**Ref: Planning Application R/90/18/HH
at no: 9 Park Drive, Rustington**

Further to the applicant's earlier applications, ref nos: R/283/17/HH and R/90/18/HH, and having inspected the details and plans of the applicant's further revised proposals as shown on the Council's website I am writing to object to the latest version of the planning application for extensions to the existing buildings at no: 9 Park Drive, Rustington.

Proposed Roof Plan

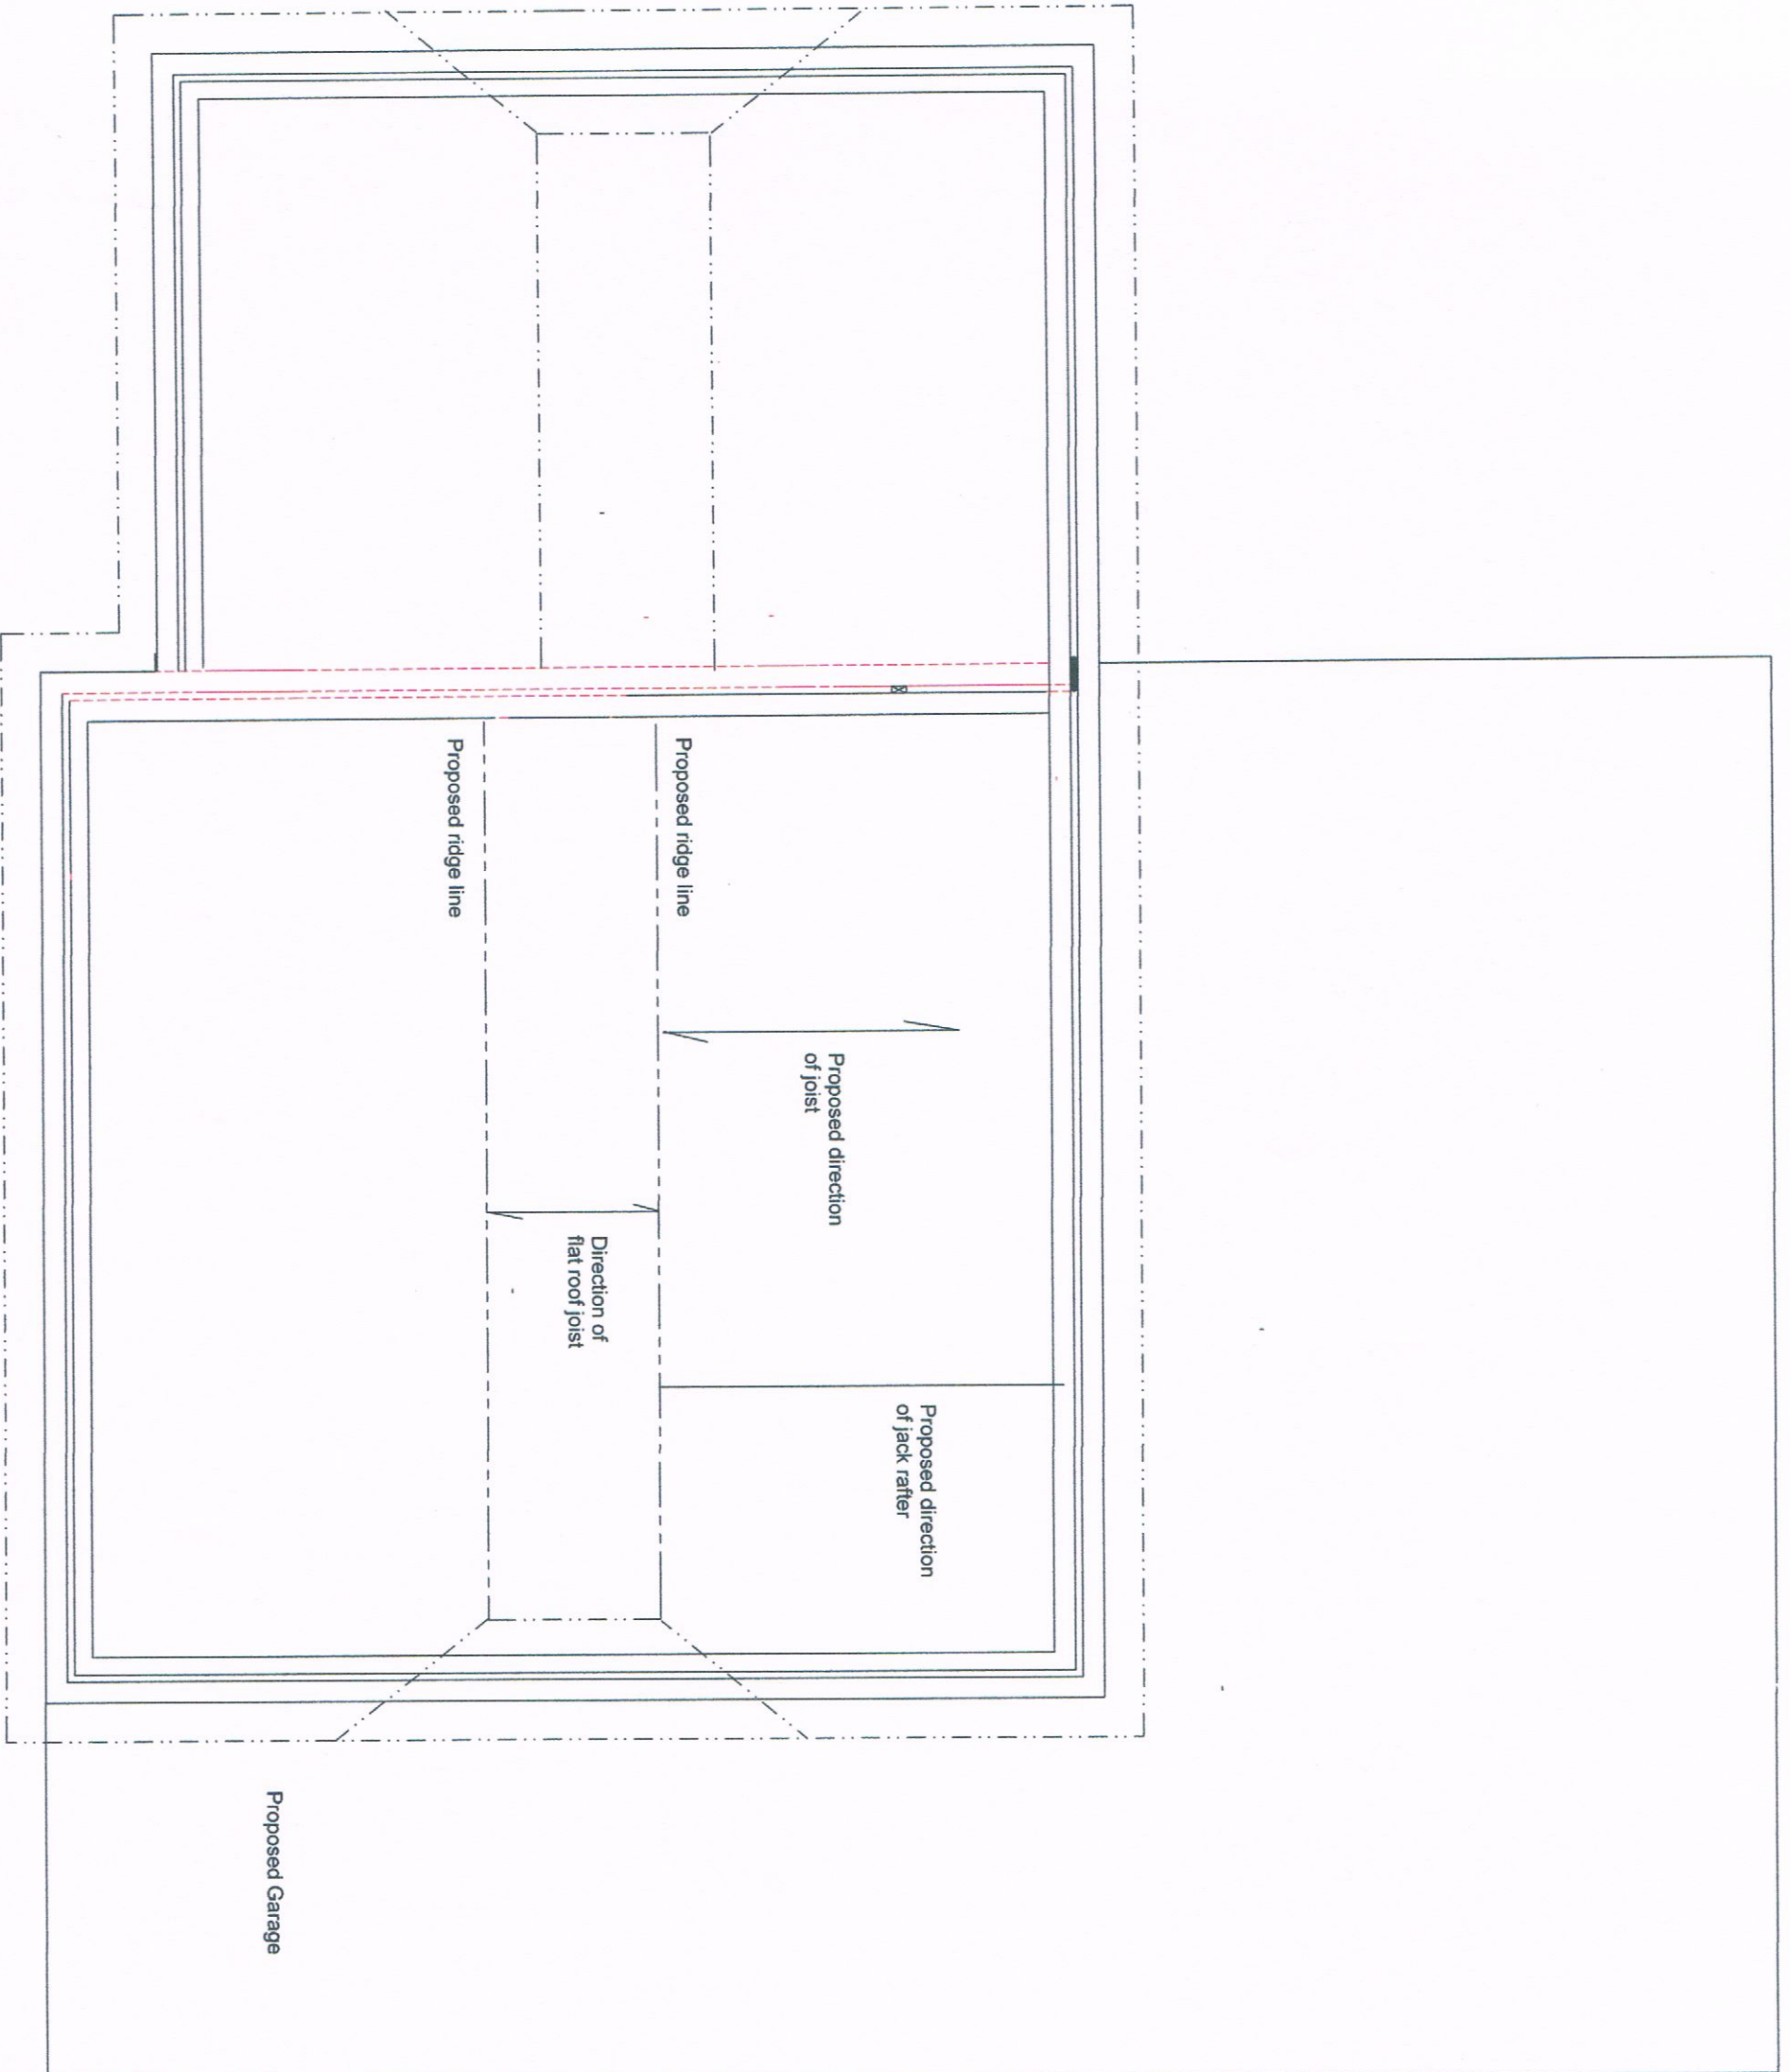
- (i) Integration with the existing building – whilst the most recently proposed extension would no longer increase the roof height of the existing building the proposed frontage runs for over 50% further than the existing.

Furthermore the significant increase arises because rotation of the principal axis of the house through 90° changes its axis from East - West to North - South and this does not relate sympathetically to, nor does it visually integrate with, the existing building.

- (iii) Overbearing effect and appearance – the greater area of the roof over the longer re-orientated roofline axis will present the appearance from the street, Park Drive, of a significantly larger frontage to the extended house than the existing one. The full height above the former conservatory, even with a larger hip, will similarly present an overbearing appearance to those looking at the now much closer gable end of the extended house from their flats on the northern side of Herne Court.

Project:
Description
Proposed Second Floor Plan

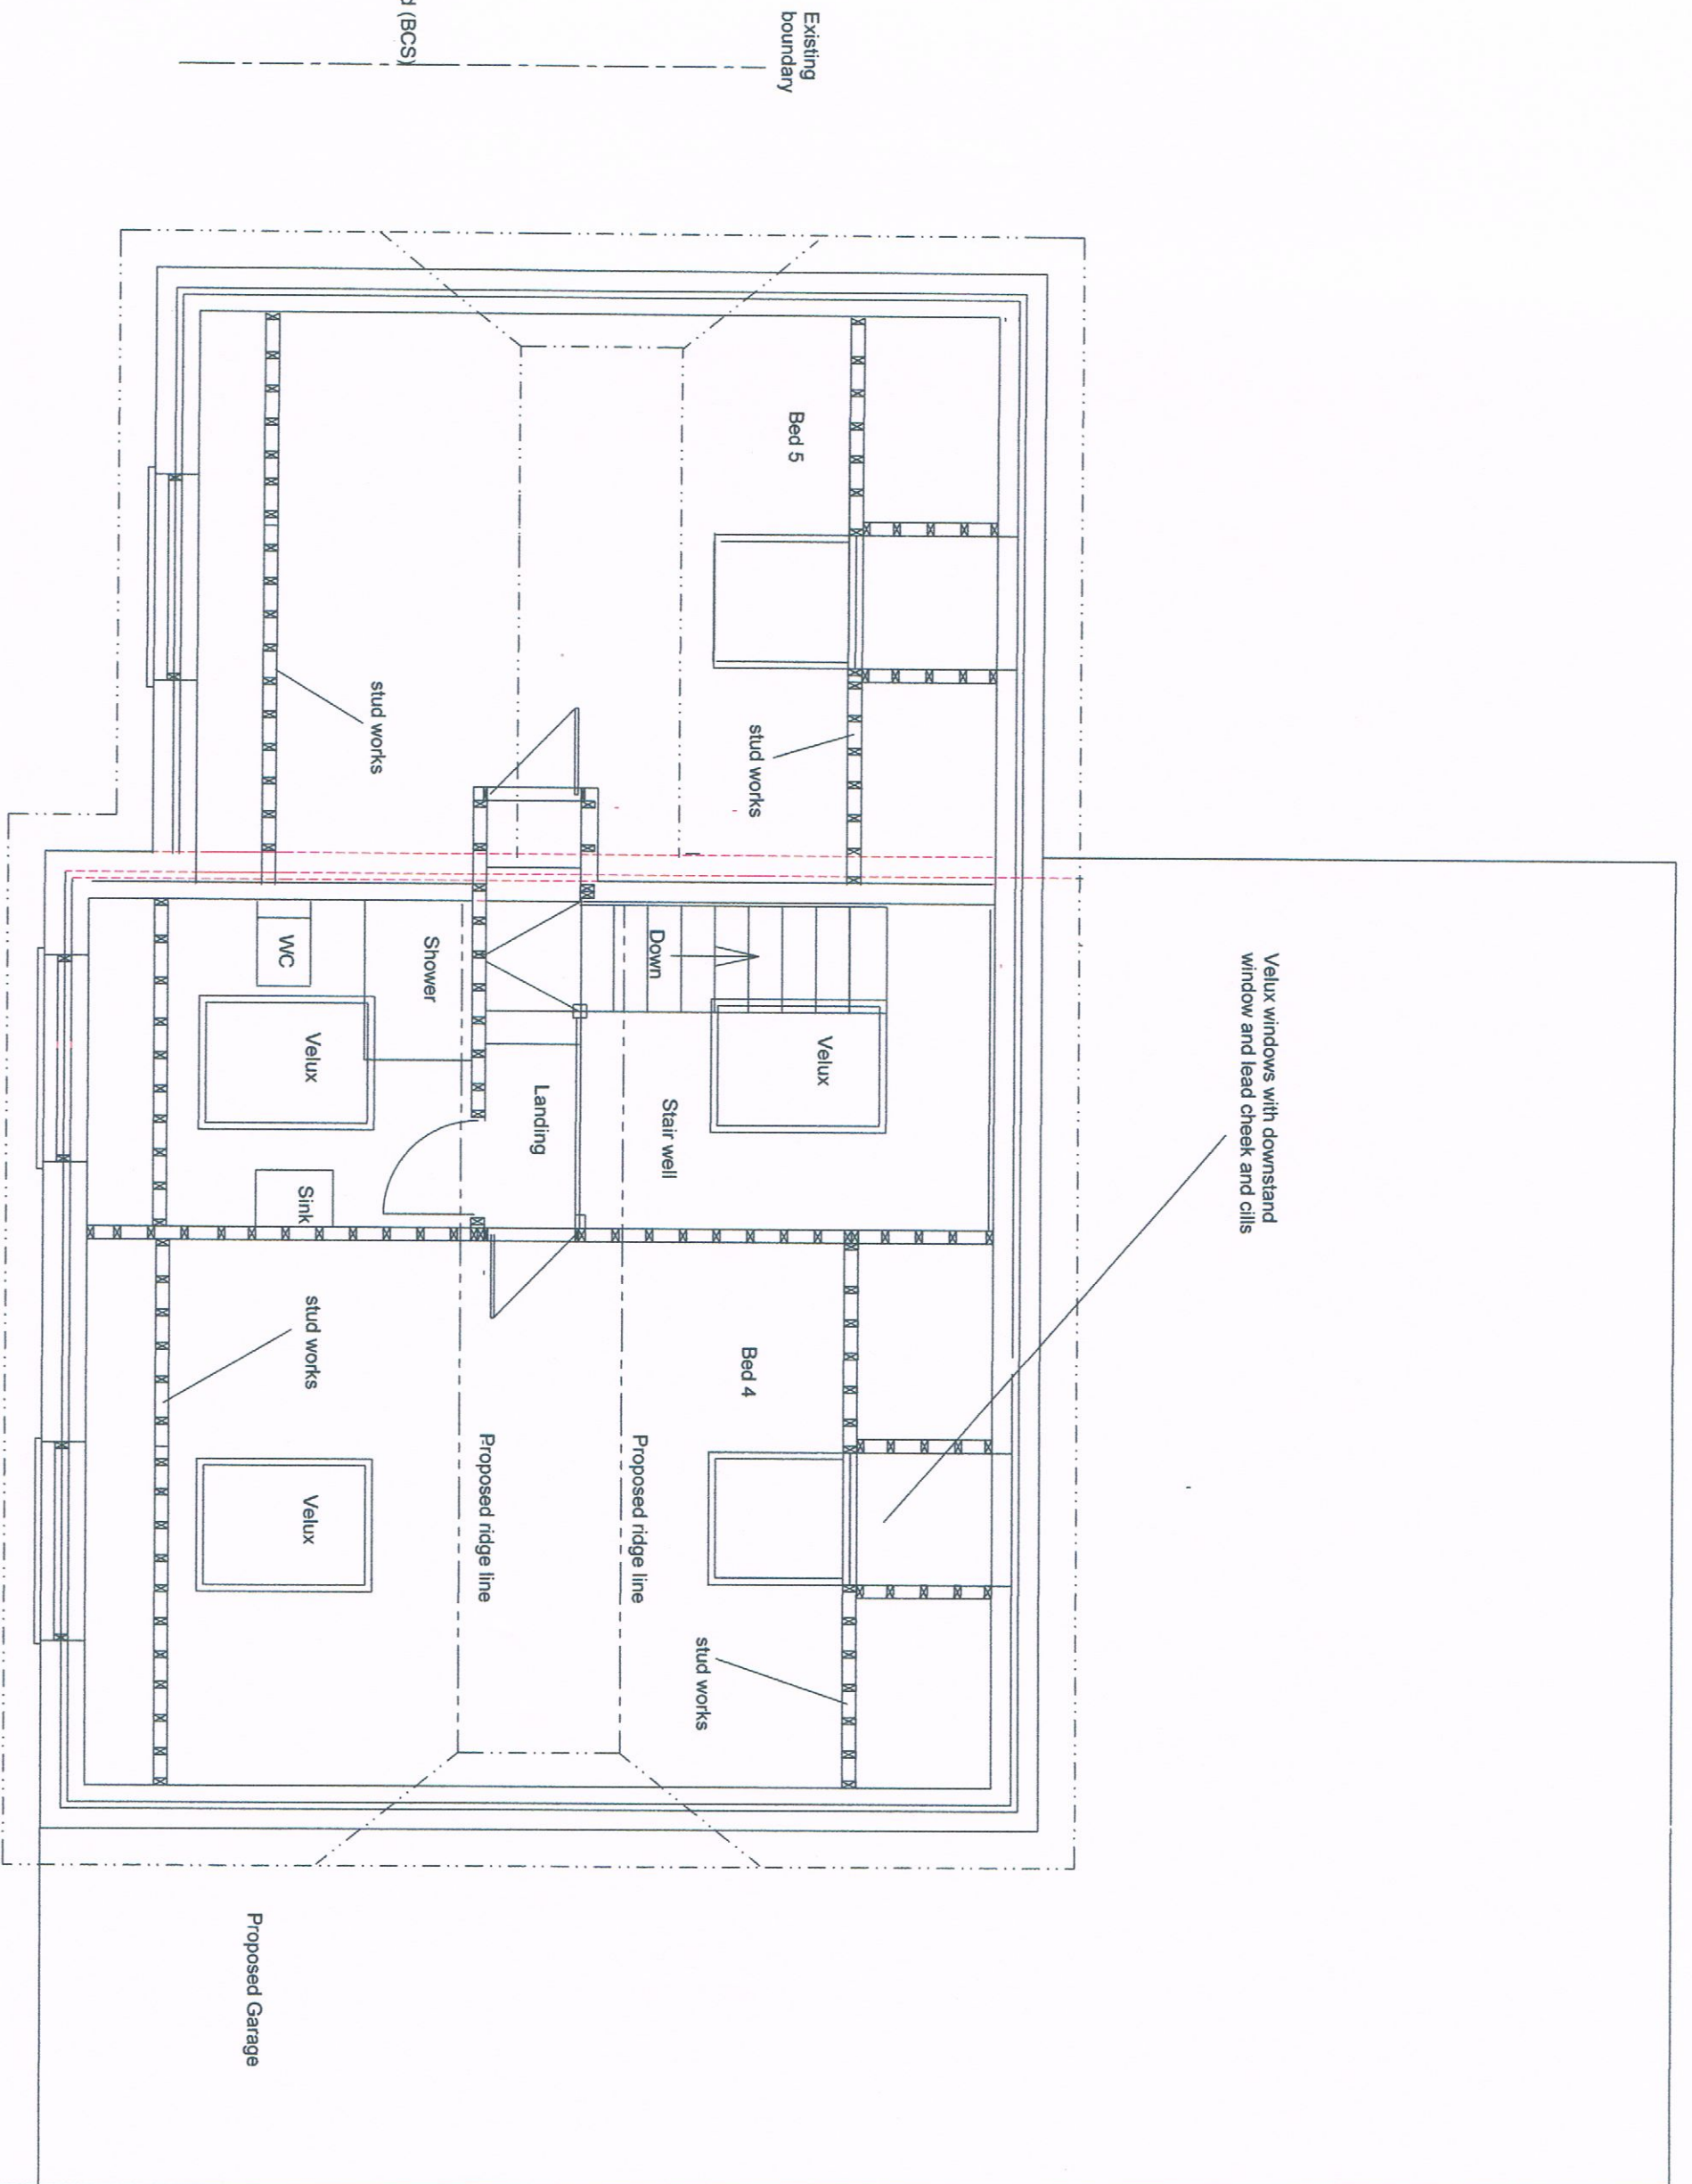
- (iv) Relation to established spatial character and pattern – the three windows in the roof at both the front and rear of the proposed extension create both the fact and the appearance of what would be the only three storey house in the road. The extension would create a house that was wholly out of character with the rest of the properties in this part of Park Drive. Indeed the mass of the enlarged building would amount to an over-development of the site.
